RE: Upgrades to ASN Company Building (SSD 8967), The Rocks- Notice of Exhibition

Steven Meredith
Regional Manager, Southern Assessments
Heritage Division
Office of Environment & Heritage
As Delegate of the NSW Heritage Council

13 May 2019

MMD-389718-S-DR-00-XX-0070

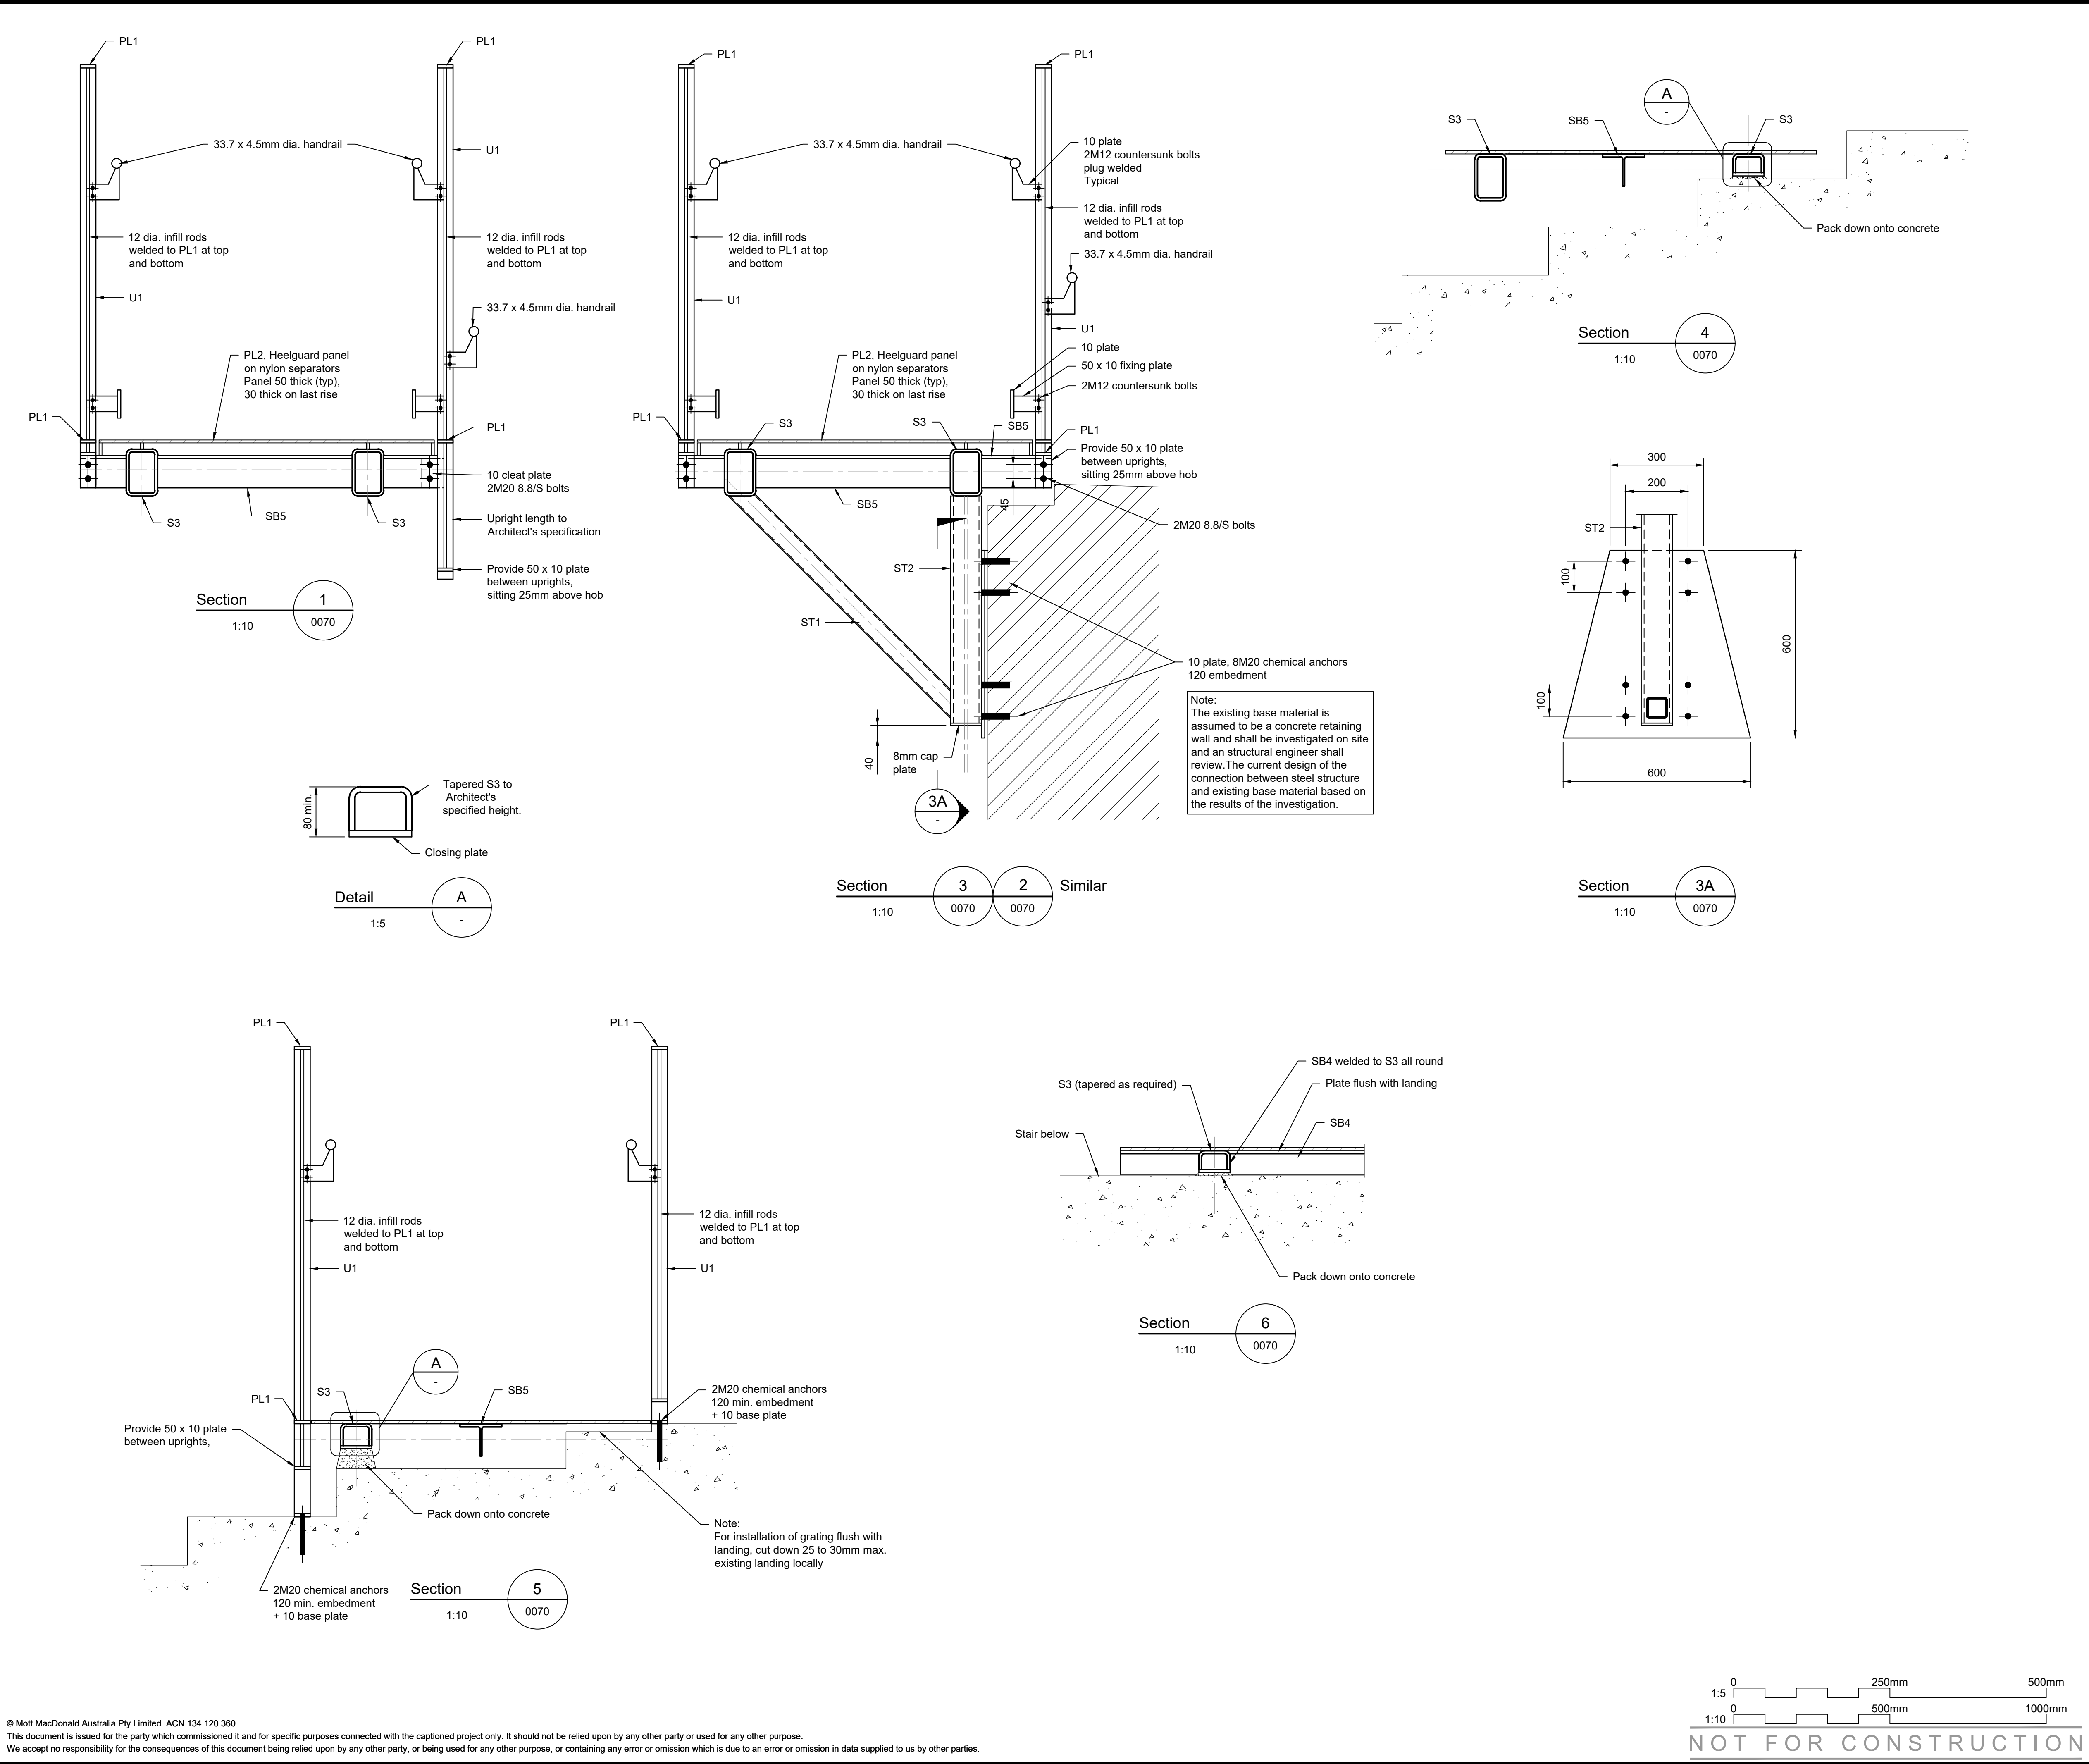
Options study and other documentation has been provided to address the SEARs and the related condition of consent of the s.60 approval granted on 16 May 2016. The documentation notes that retention of existing balustrade and inserting a new one behind is not feasible due to insufficient space available. However, the deficit appears to be marginal and it appears that this option may be achievable through slight modifications. Overall, there are still concerns regarding the proposed scheme comprising a replacement balustrade

radically different from the existing as it will disturb the consistency across the overall front elevation and have a considerable visual impact on the principal elevation. It is recommended that design improvements to the front ramp and balustrade are explored, including retention of existing balustrade, or further information provided in support of the proposal.
